City of Albuquerque Stormwater Construction Site Inspection Report

| Project Name and Location | <u>Range Cade</u> <u>Rio Grande and I 40</u> | | |

From: Cherne, Curtis
Sent: Friday, September 16, 2016 9:02 AM
To: 'aecllc@aol.com'
Subject: RE: CPN 759460 fireline sediment control BMP

From: Cherne, Curtis <CCherne@cabq.gov>
To: kelly <kelly@goodwinengineers.com>; aecllc <aecllc@aol.com>; 'egarcia@garciacars.com' <egarcia@garciacars.com>
Cc: Wolfenbarger, Jeanne <jwolfenbarger@cabq.gov>
Sent: Thu, Sep 15, 2016 10:08 am
Subject: CPN 759460 fireline sediment control BMP

THE RANGE CAFE
RIO GRANDE
EROSION & SEDIMENT CONTROL PLAN

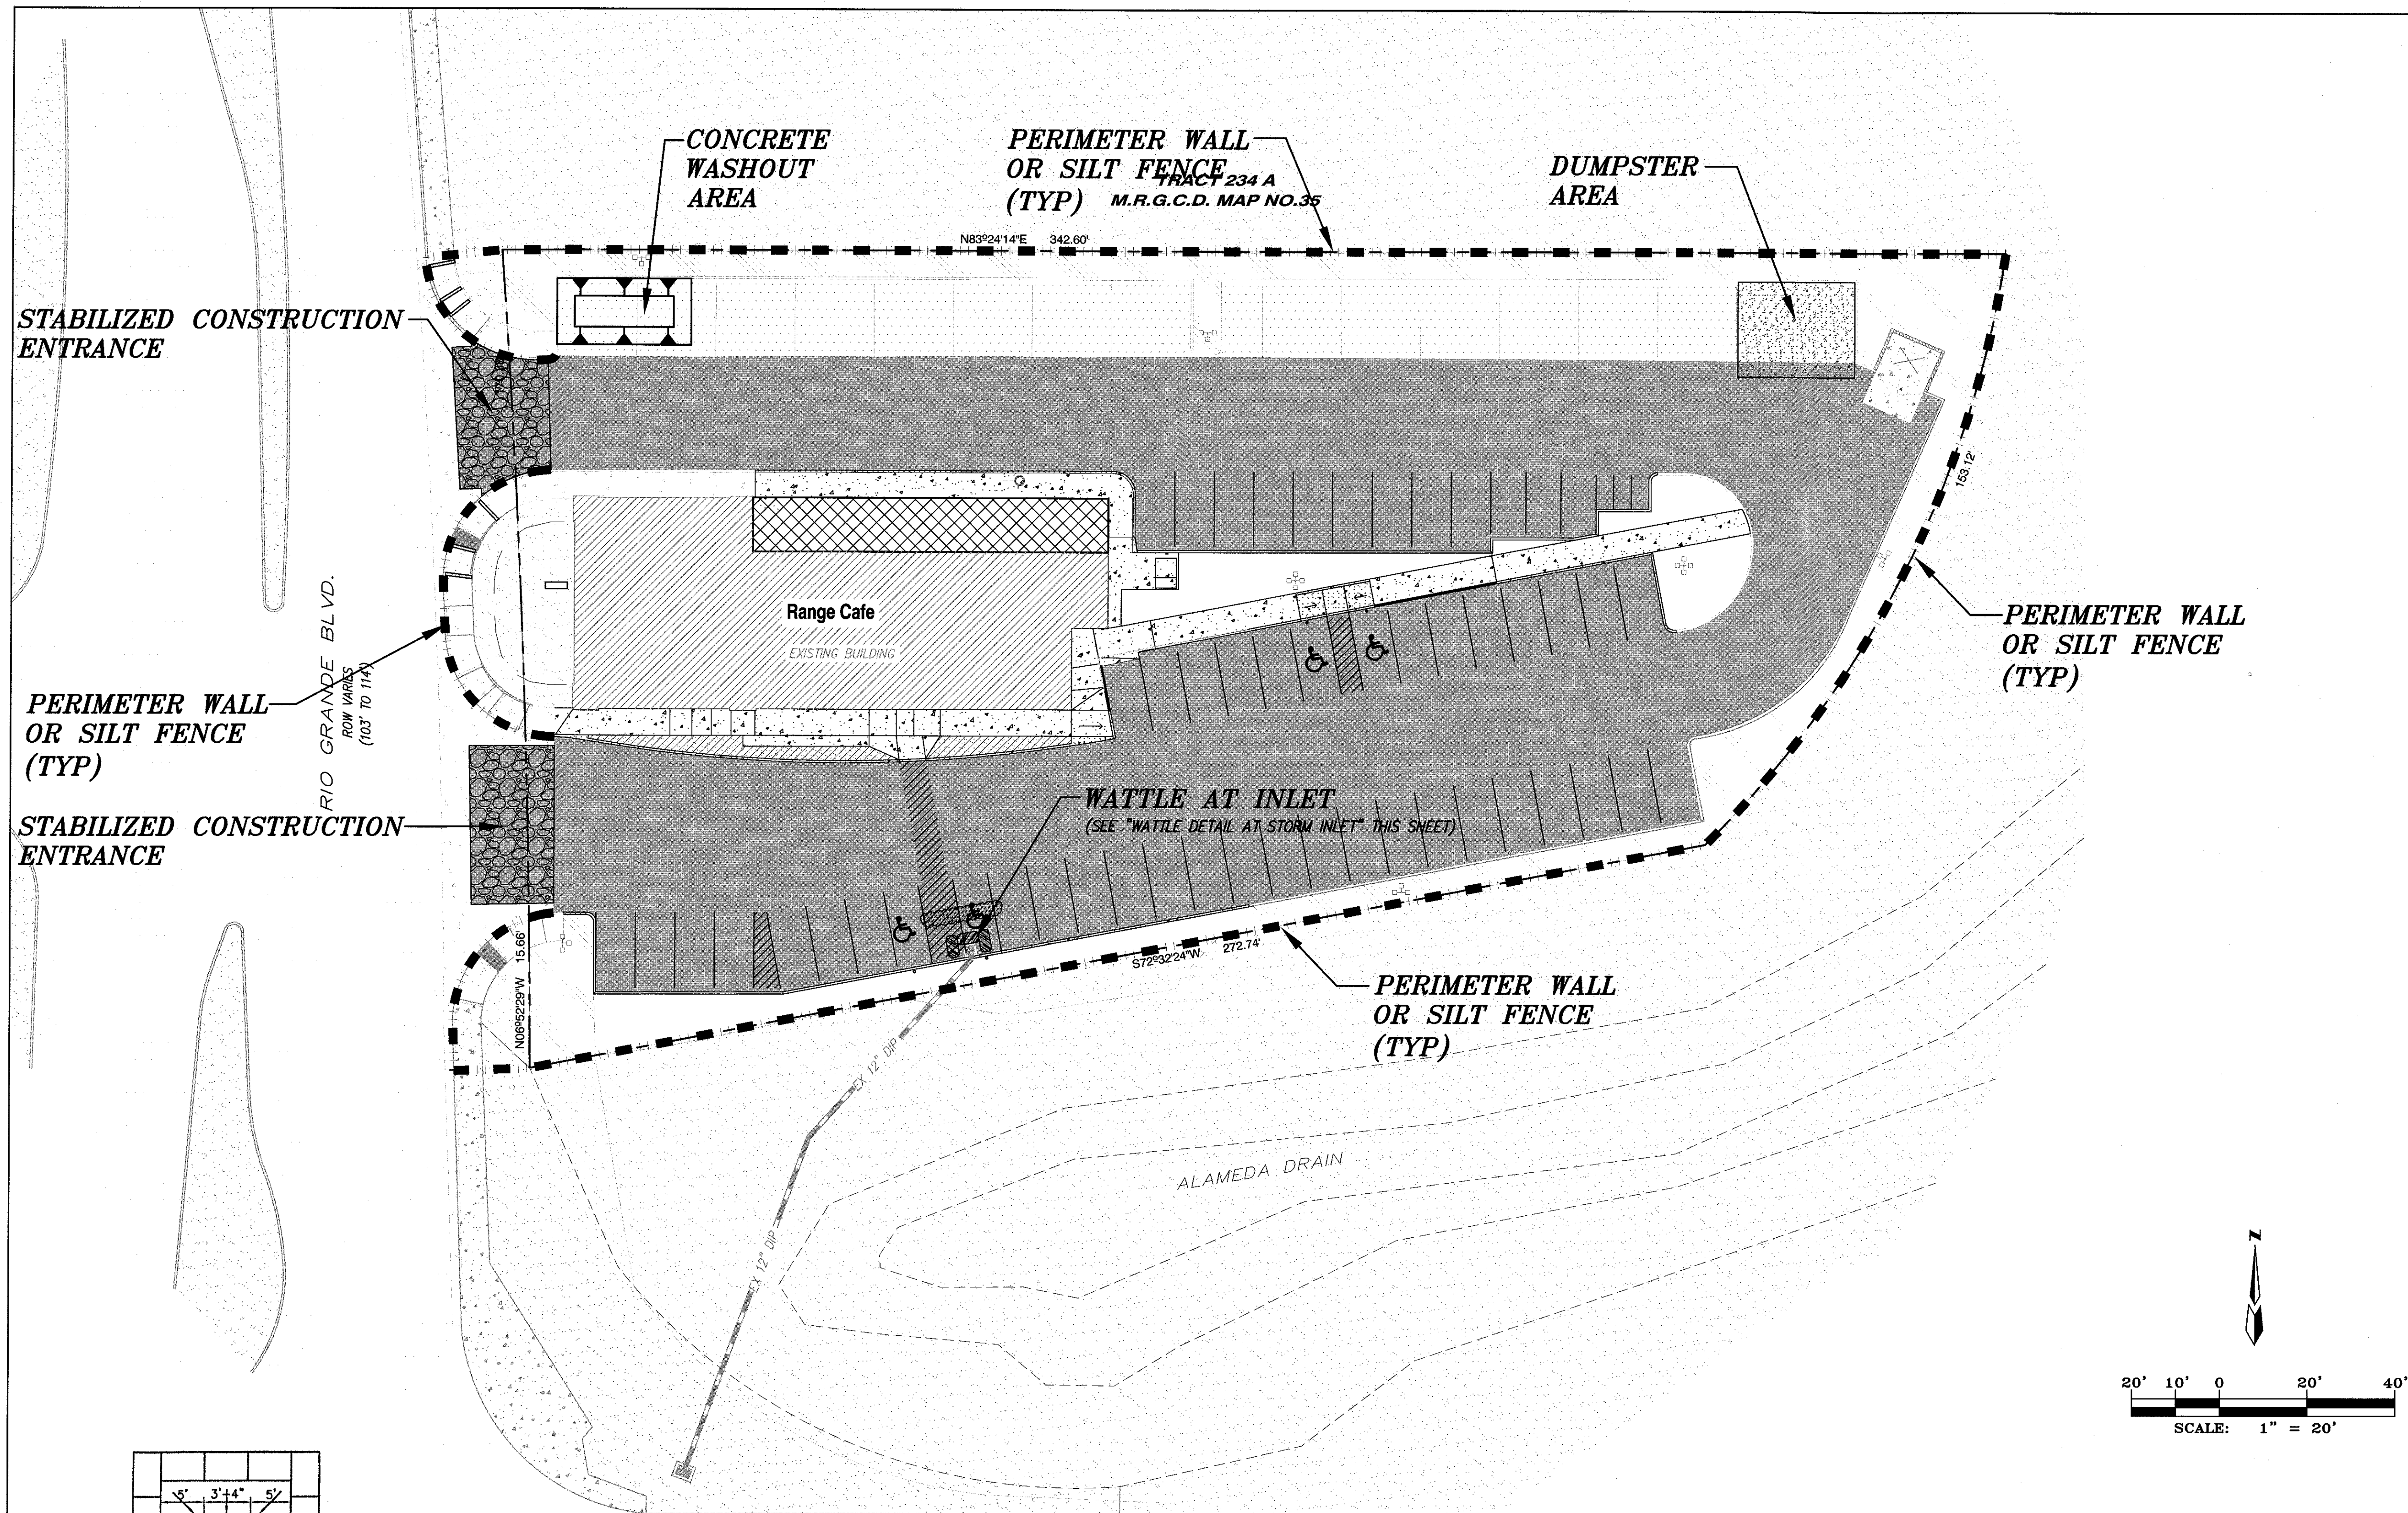
Protection for this work was not shown on the approved ESC plan. I figured since it was a TI, a street cut would not be required. Rather than having to resubmit the plan, I figured we could work it via e-mail.

Transverse street cuts require the following:

1. Placing the excavated dirt on the uphill side of the utility cut (north?)
2. Or placing a mulch sock or wattle at the toe of the slope if the dirt is placed on the downhill side of the cut.
3. Another method would be to provide inlet protection.

Please clean the street prior to flushing/testing or similar that may introduce water into the street.

This area is directly connected to a MRGCD drain which is directly connected to the Rio Grande and therefore requires more attention.

I got your email. We can follow your recommendation. Do I need to send you any thing or just acknowledging this email is ok? Let me know.
